Development Control
Ribbles Valley Borough Council

App no: 21.0600

Address: Land off Ribchester Road, Clayton-le-dale

Proposal: Discharge of condition 7 (scheme for construction of site access and the off-site works of highway improvement) pursuant to planning permission 3/2020/0807 Proposed agricultural building for the housing of sheep, cattle and storage of farming equipment. New farm track and concreting.

Proposed Site Access Plan- 1:500

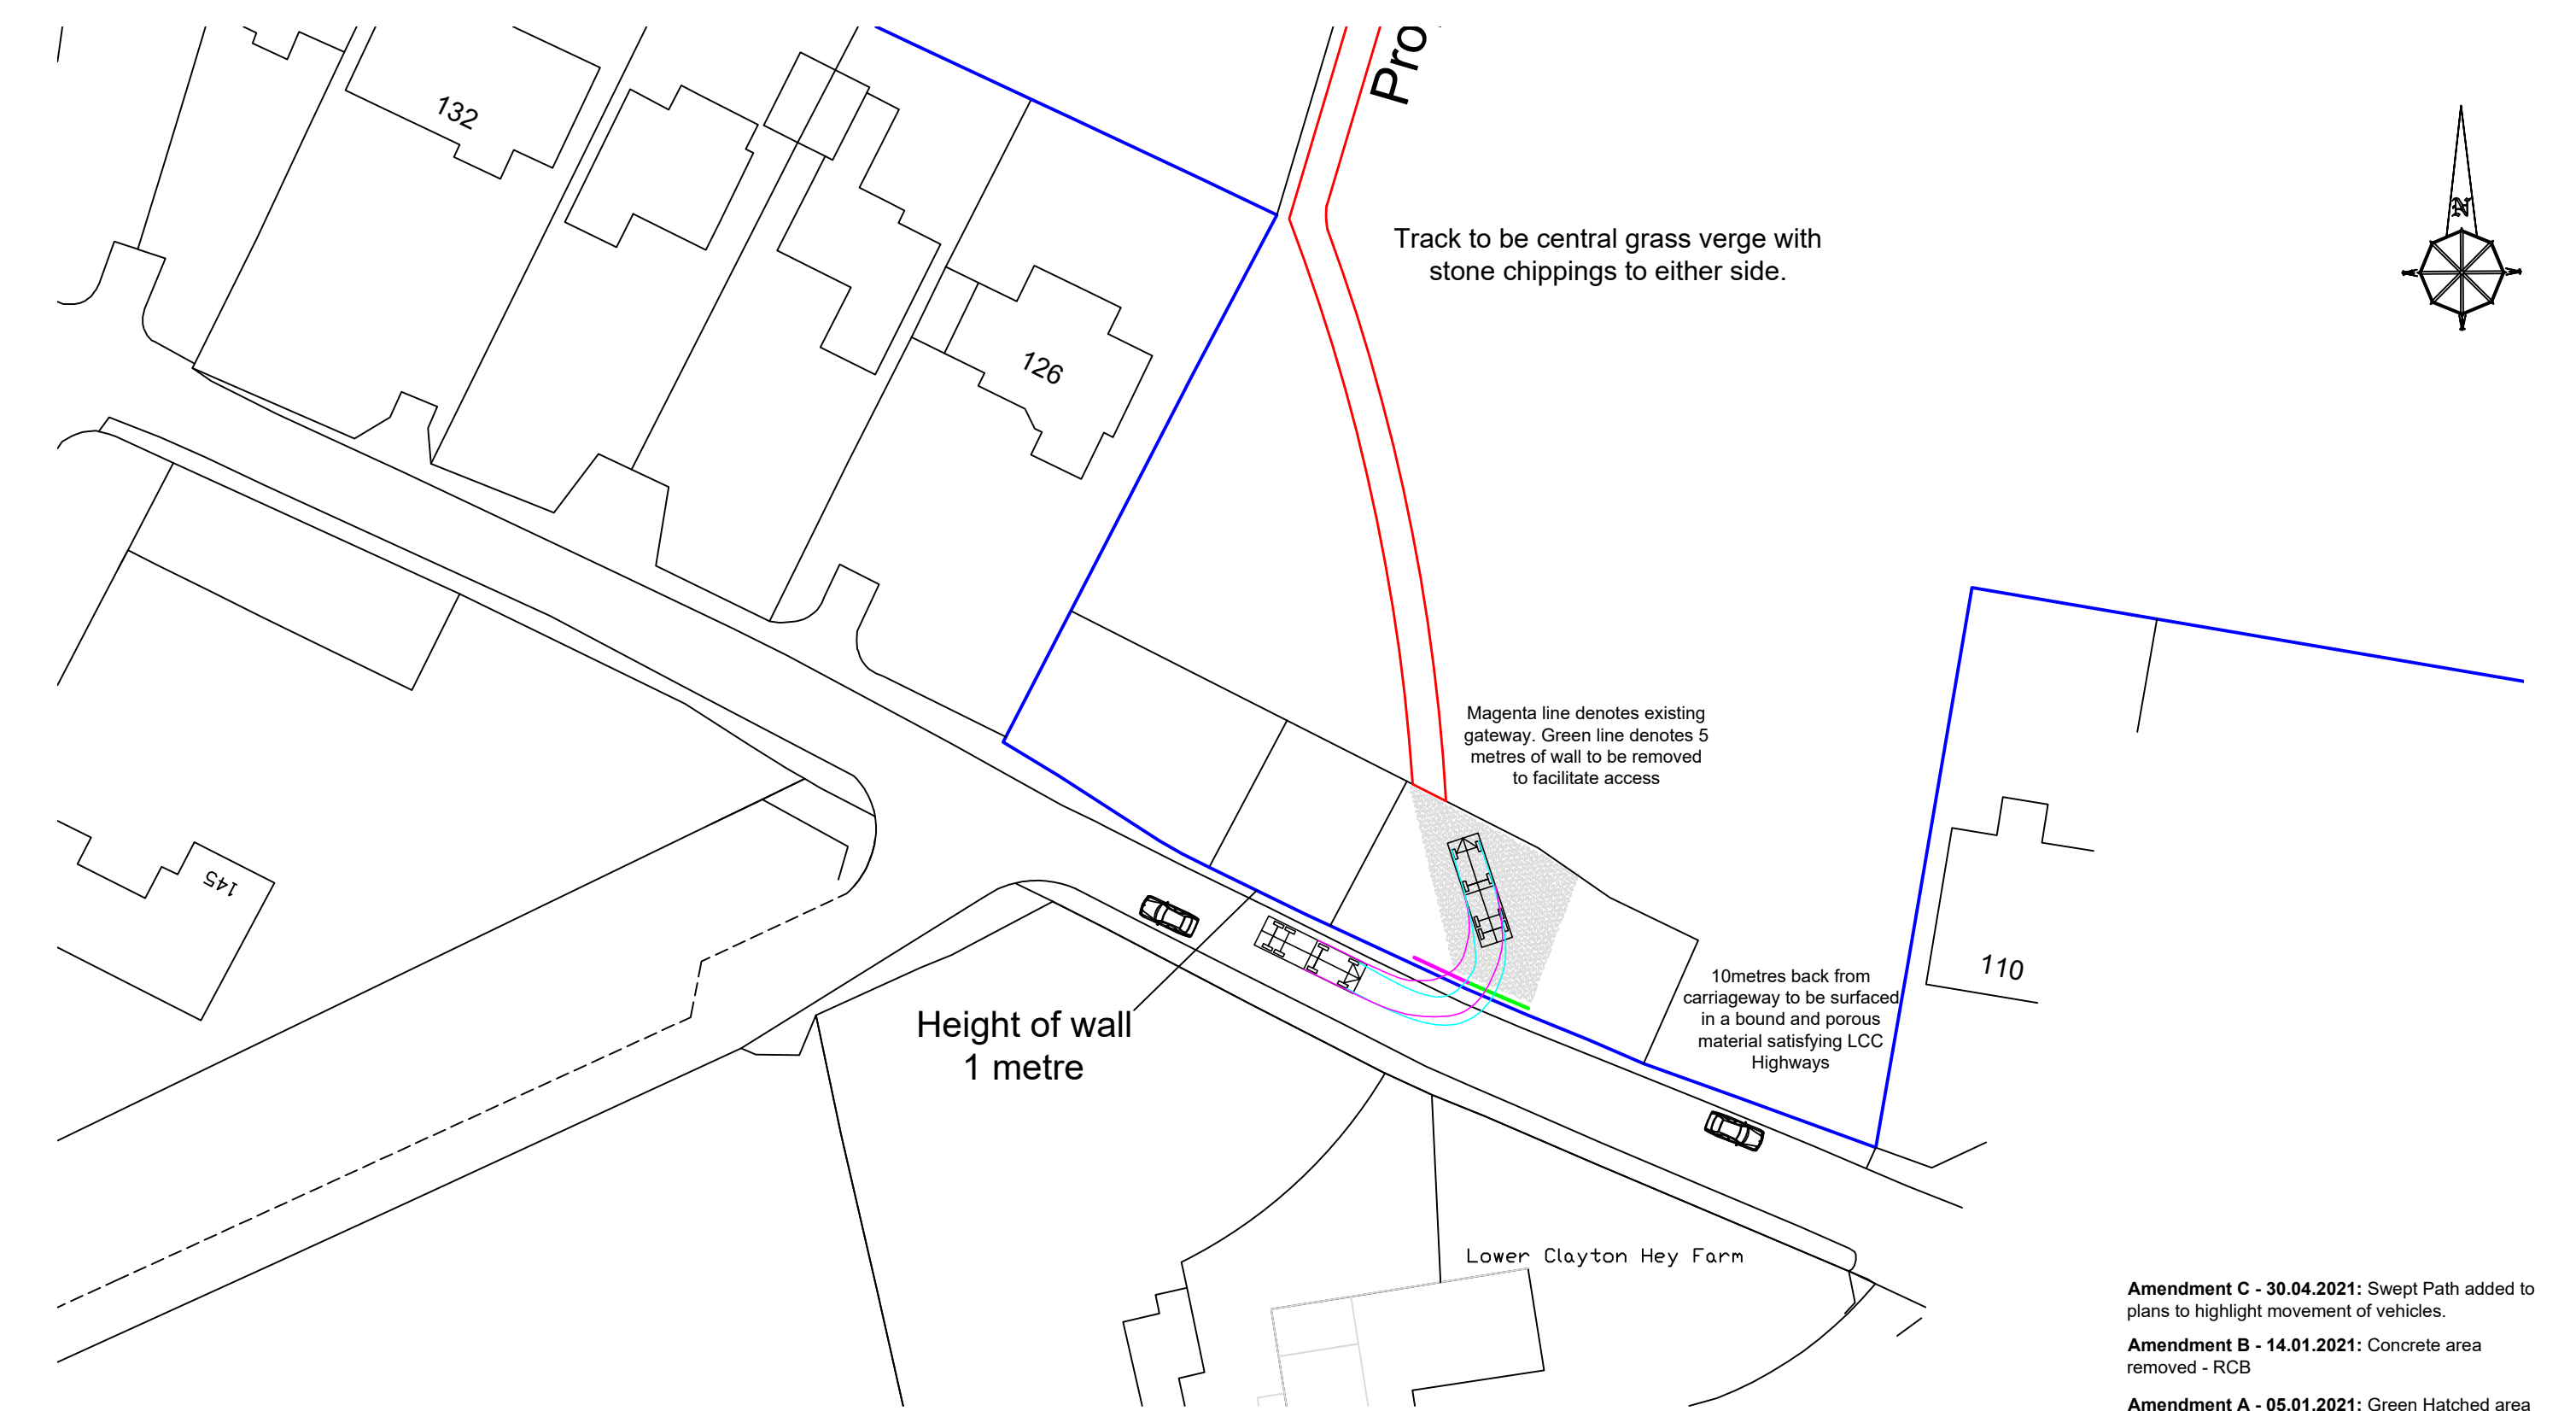
The submitted details are insufficient to allow the discharge of this condition.

Detailed drawings to include the boundary and gating arrangement (set-back from the edge of carriageway for the longest vehicle), the widening and tie-in detail of the surface material to the existing carriageway, edging detail and surface water drainage.

The applicant needs to contact Lancashire County Council by email developeras@lancashire.gov.uk to progress the S278 agreement and obtain technical approval for the access works before this condition can be discharged.
